**KIRKLEES METROPOLITAN COUNCIL
INVESTMENT & REGENERATION SERVICE**

**DELEGATED DECISION TO DETERMINE PLANNING APPLICATIONS TO
CARRY OUT DEVELOPMENT WITHOUT COMPLIANCE WITH PLANNING
CONDITIONS PREVIOUSLY ATTACHED**

Reference No: 2017/70/92557/W

Description: Variation condition 1 (plans) on previous permission
2016/93365 for reserved matters application pursuant
to outline permission 2014/91533 for erection of 30
dwellings

title
The Northwood- PLOT 30
Proposed Double Garage & Conservatory

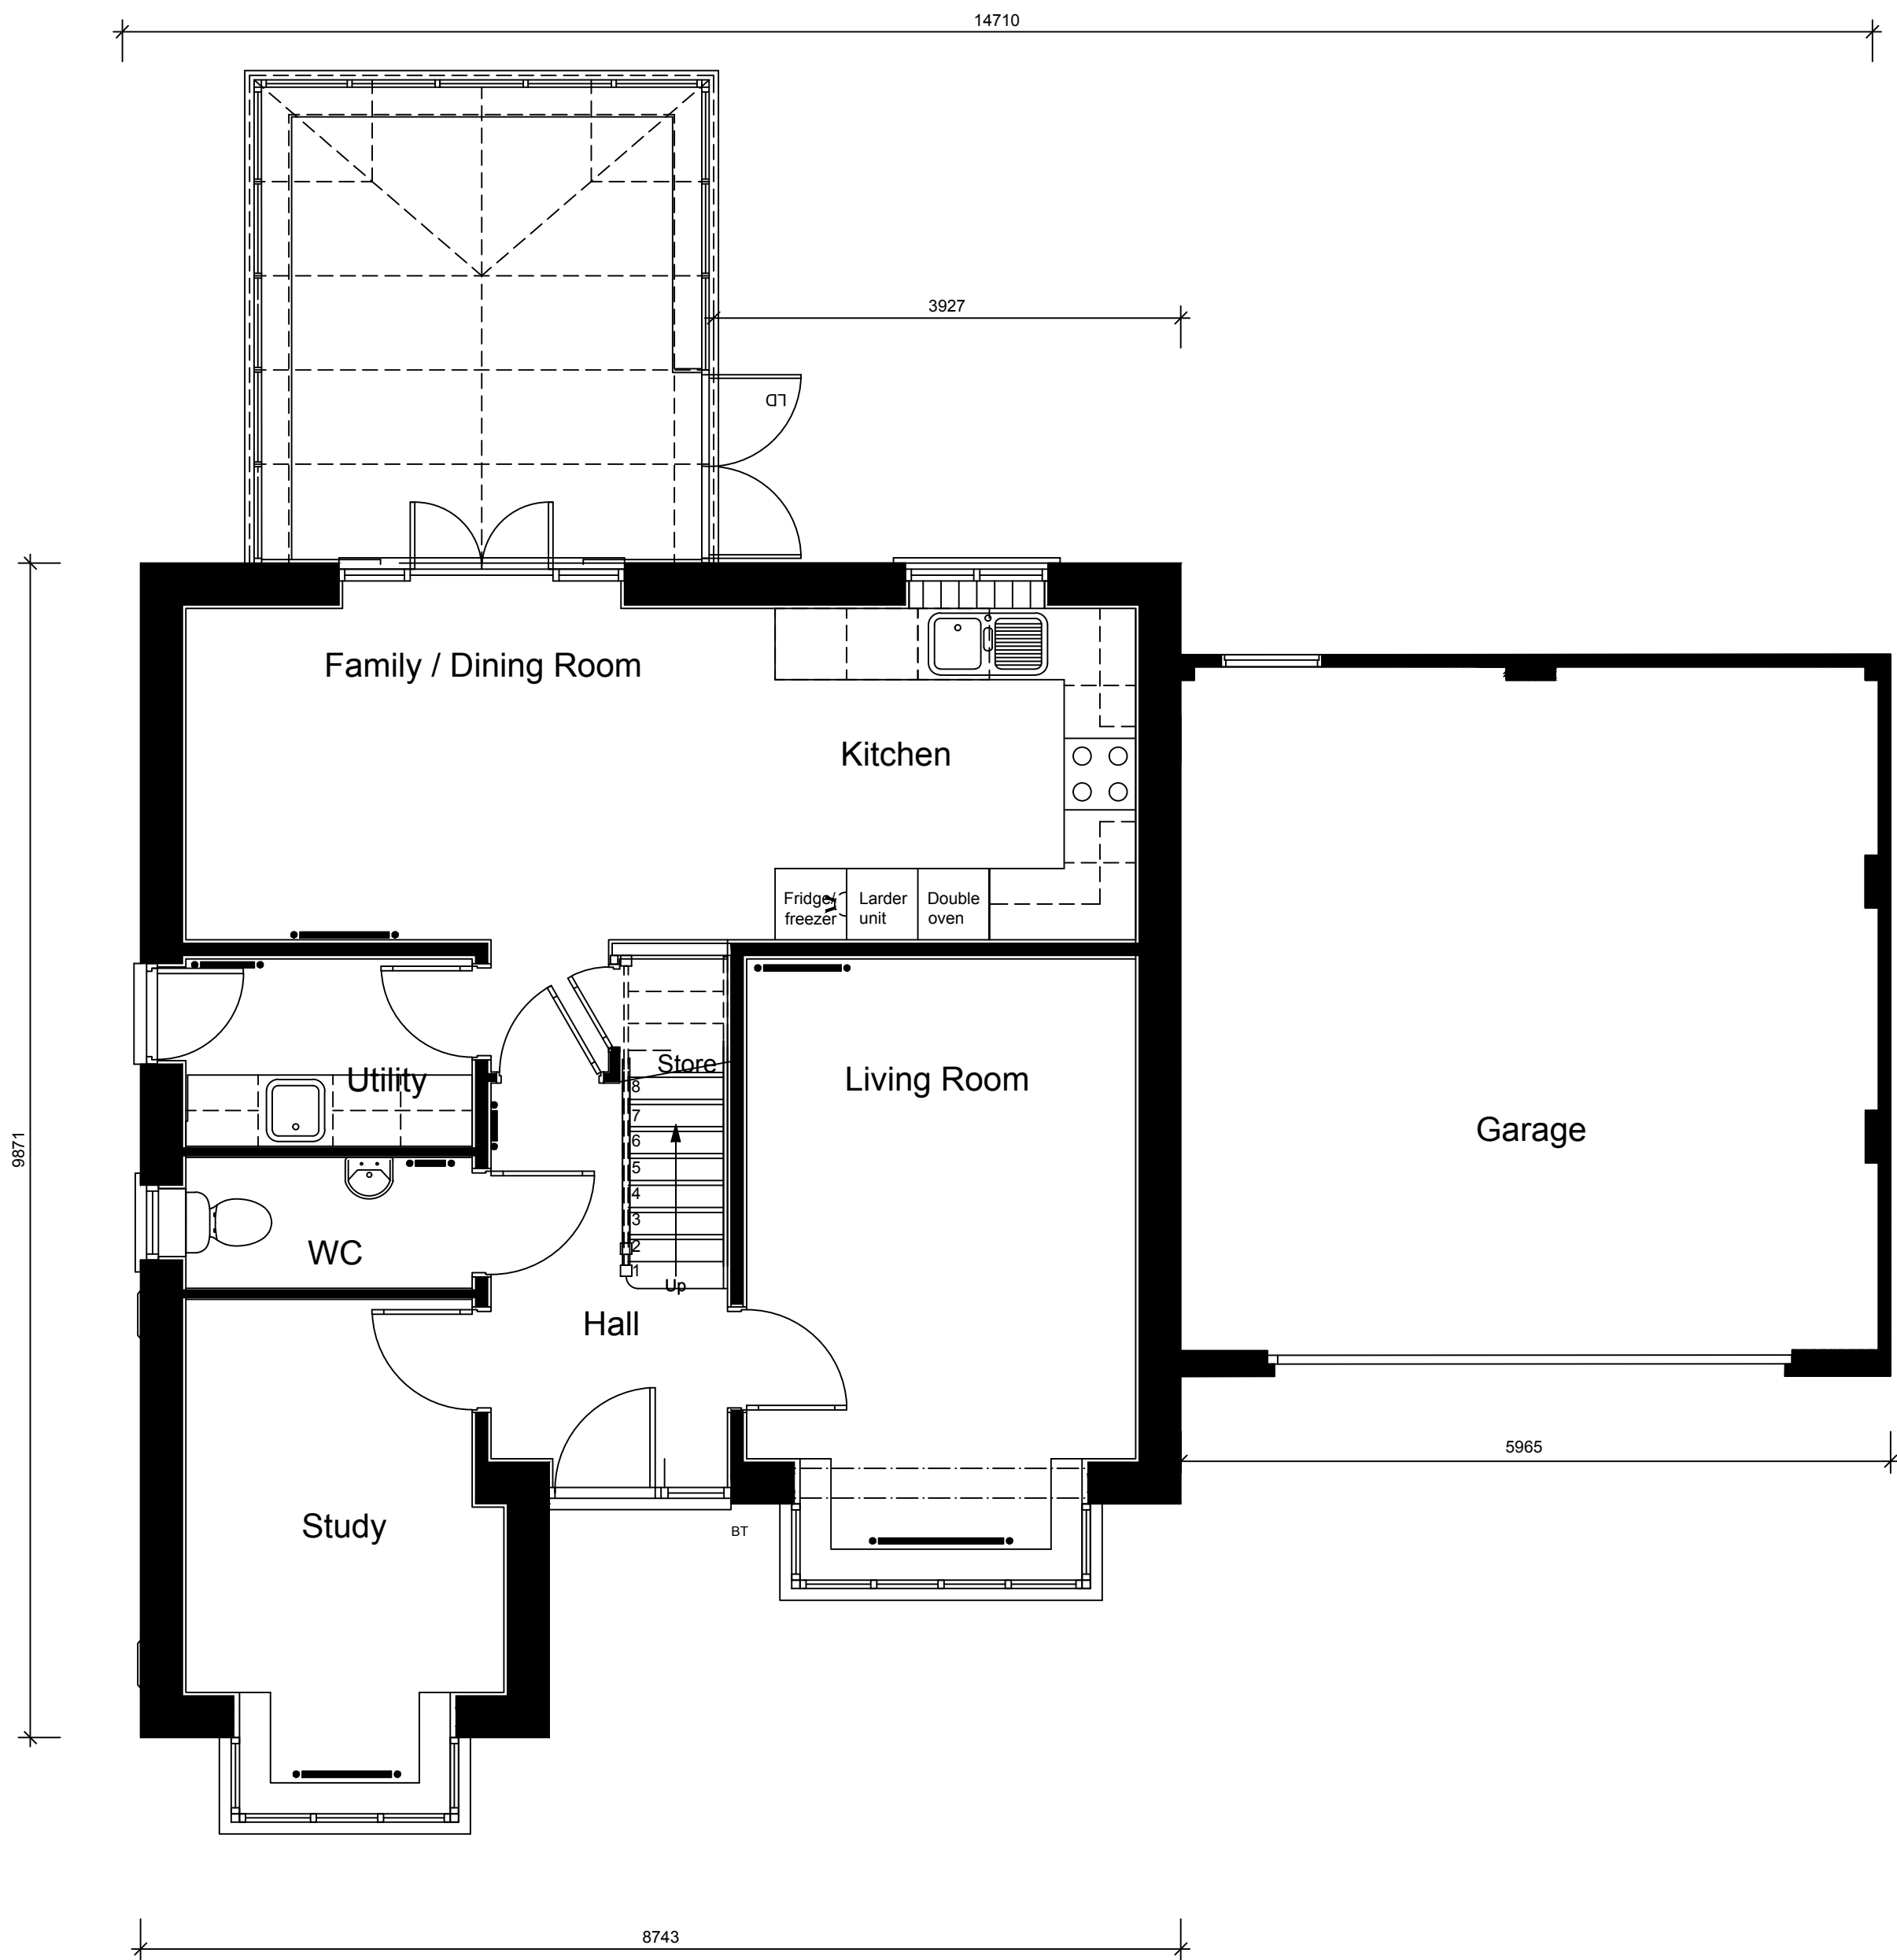
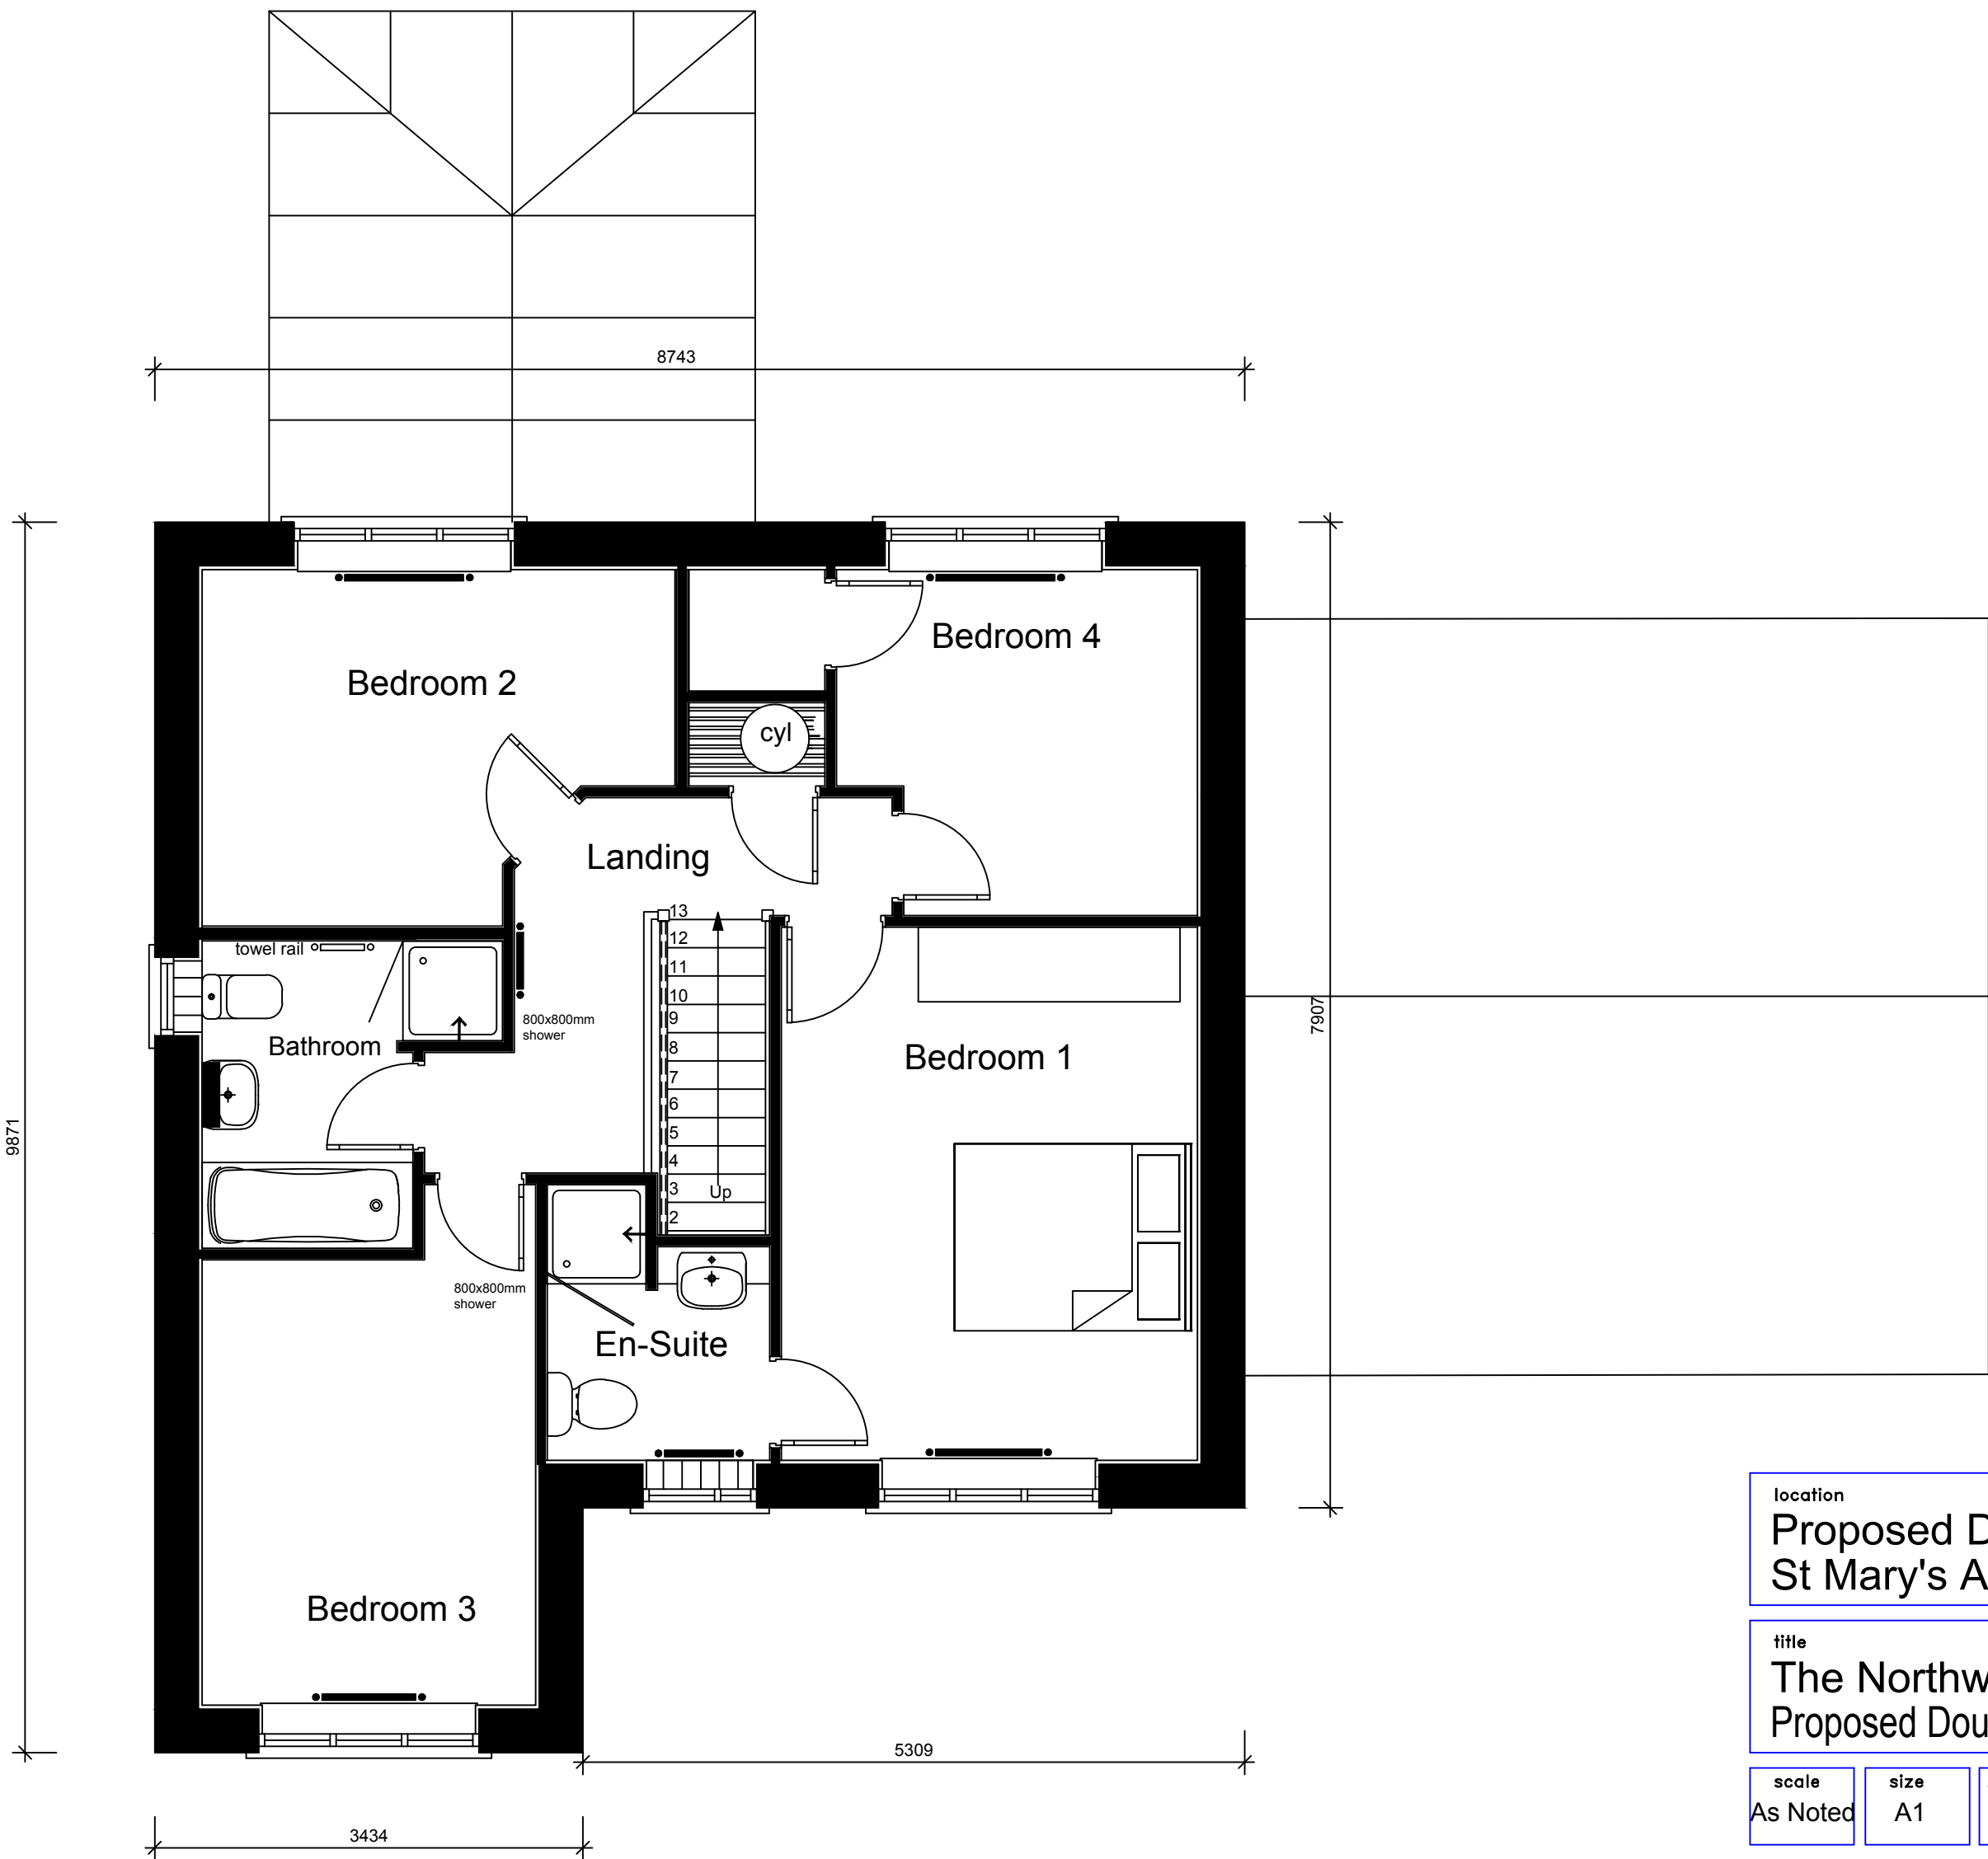
Plot 30: The house type remains the same but it is proposed to make the attached single garage into a double garage and add a conservatory to the rear elevation. The dwelling is also repositioned 0.8m to the west of its approved location to facilitate the enlarged garage. The main reason for the proposed change is because the applicant wants to use this property as a show home with the double garage forming the sales office.

The conservatory to the rear of plot 30 is also considered to be acceptable. It is of a proportionate size and would not have any significant impact on neighbouring property. It is around 8m from the boundary with 6 St Mary's Avenue and 21.5m from the side wall of this neighbouring dwelling. The developer has decided to re-orientate the conservatory doors towards the length of the garden rather than towards 6 St Mary's Ave to mitigate any potential privacy concerns, albeit the neighbour had not raised any specific concerns with the conservatory. The rear wall of the conservatory is well separated from properties to the south and there would be screening on the boundary. The conservatory would be screened on the eastern boundary to plot 28 by timber fencing.
